Rossendale Borough Council

App no: 23.0524

Address: Former Anacapri Restaurant Helmshore Road Helmshore

Proposal: Approval of Details Reserved by Conditions 2 (Material Samples), 4 (Remediation), 5 (Off-Site Highway Works) and 9 (Landscaping) pursuant to planning approval 2023/0044

PROPOSED ROAD FRONTAGE: PLOTS 3-5
A2170-BR-SP06

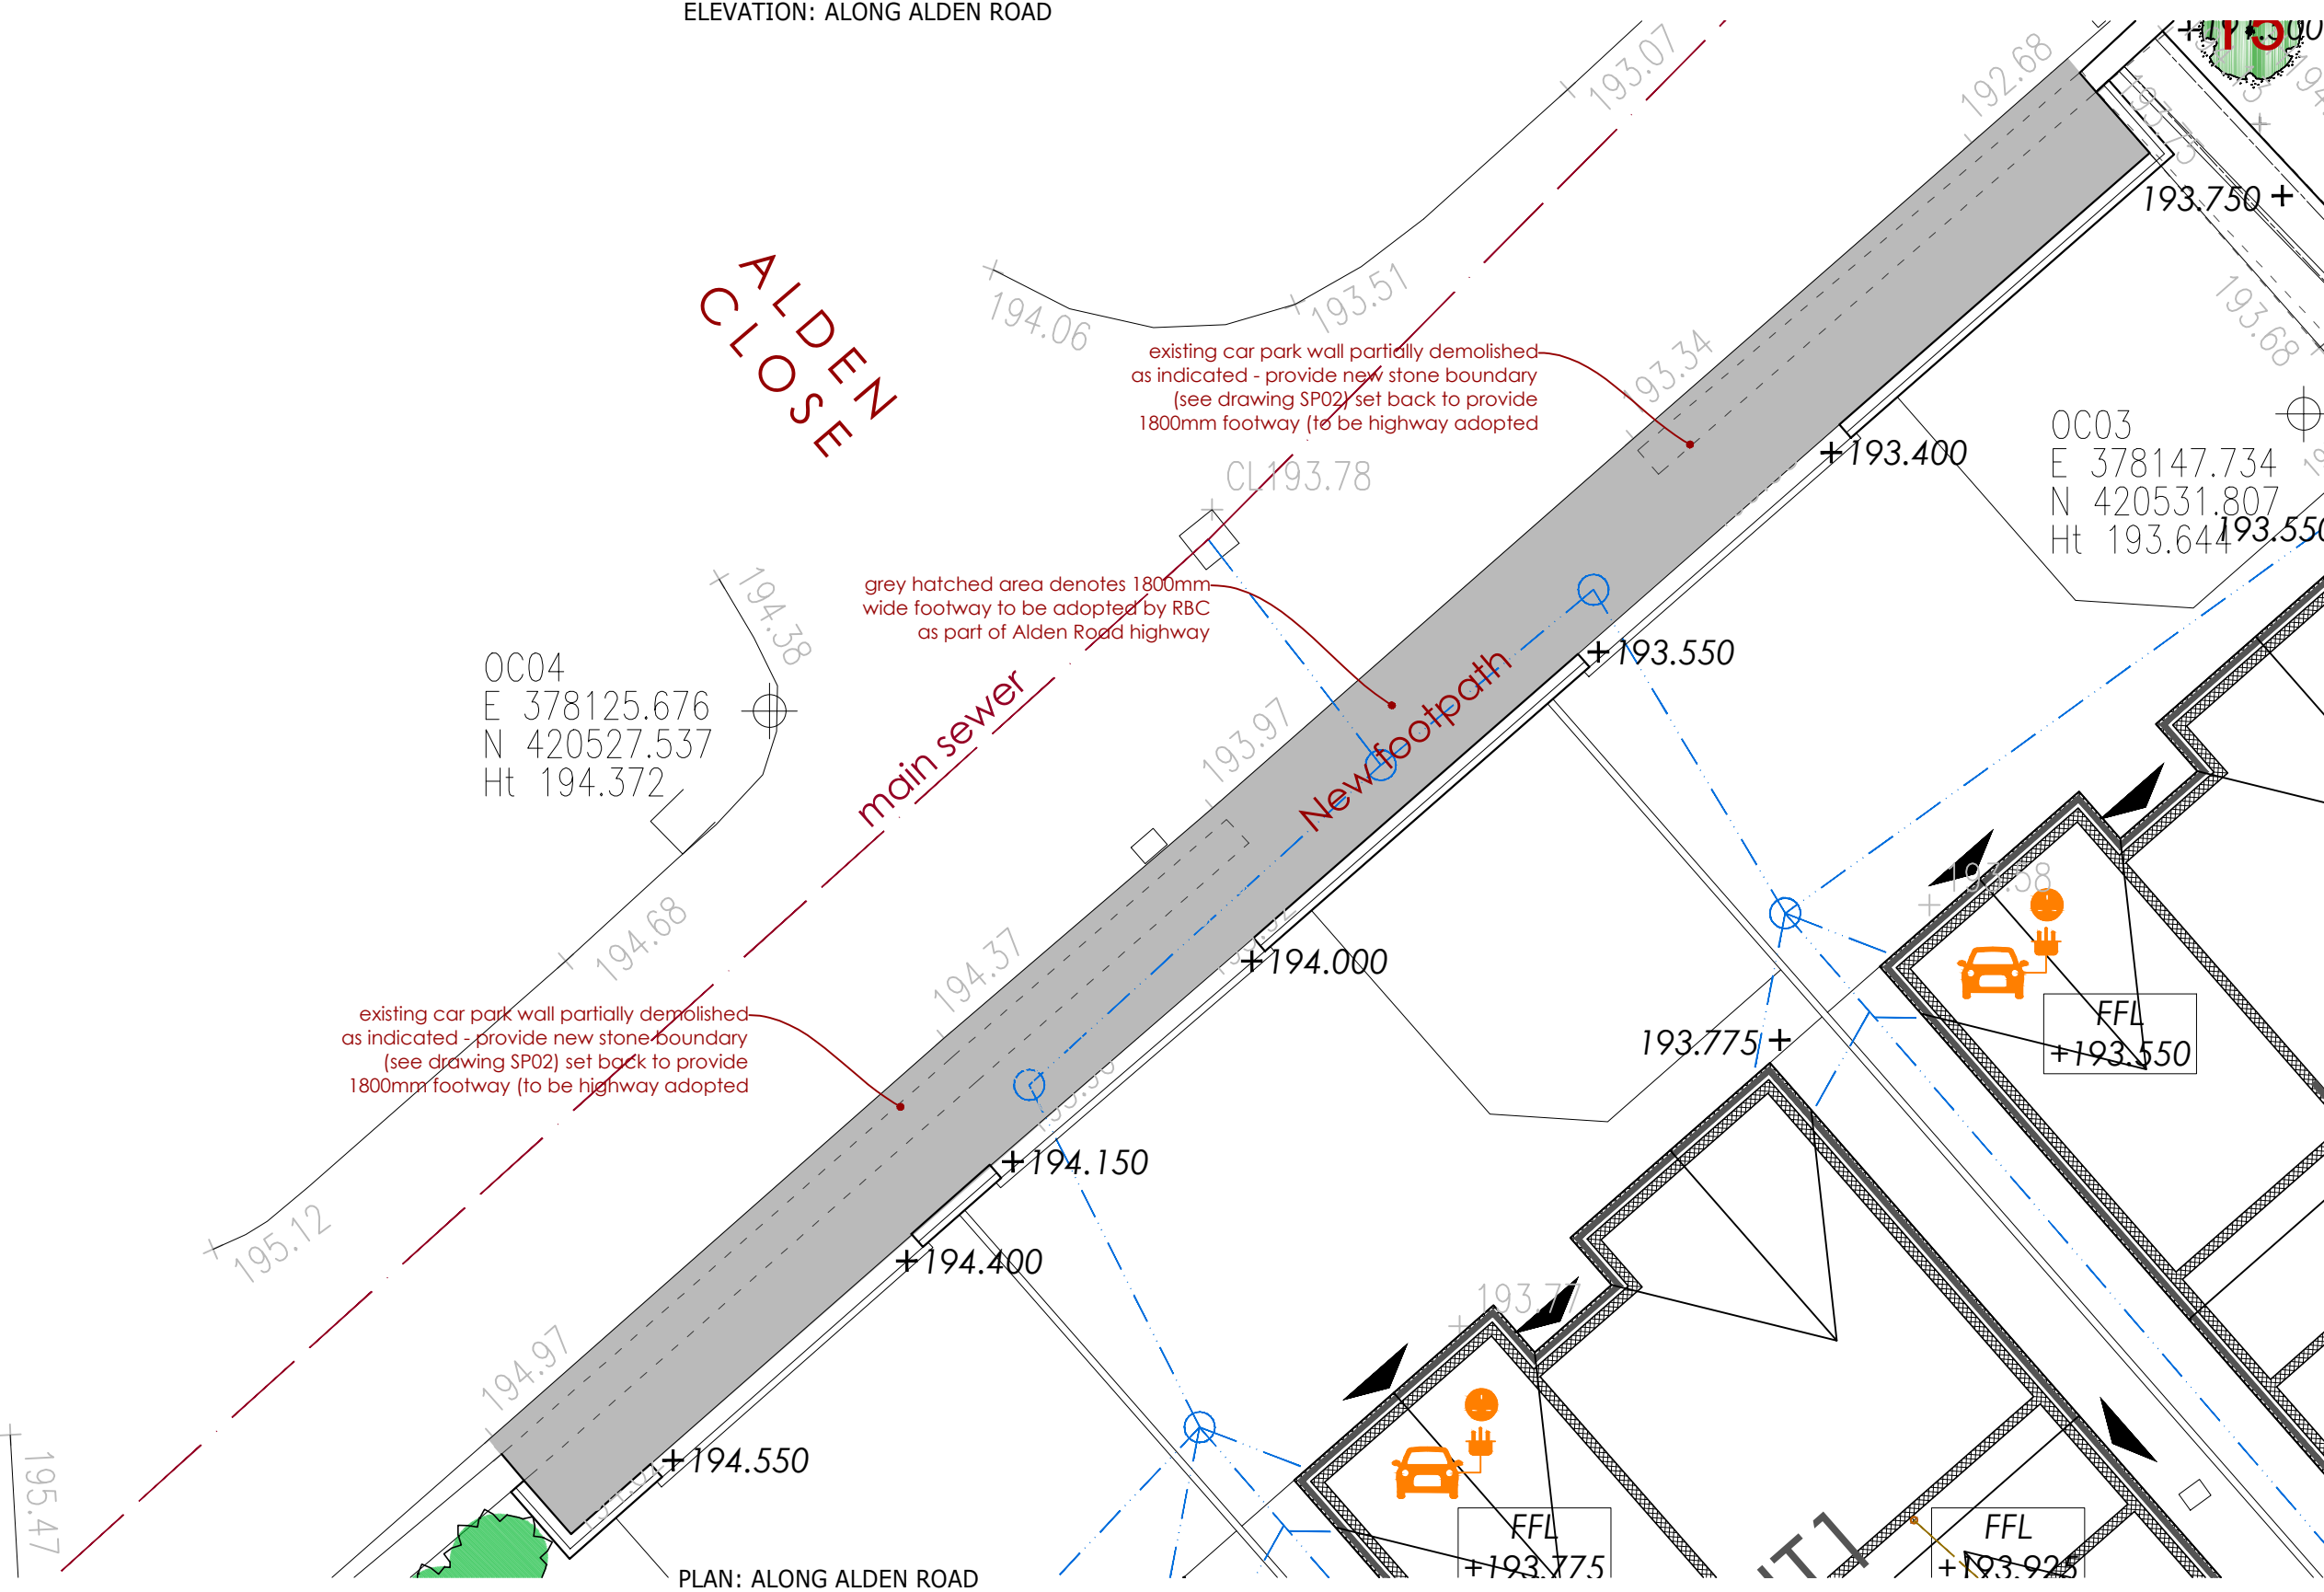
'Proposed road frontage plots 3-5' omits the section of footway along the Alden Road frontage of plot 5. This needs to be footway for the full frontage, as shown on the layout approved under application 2023/0044.
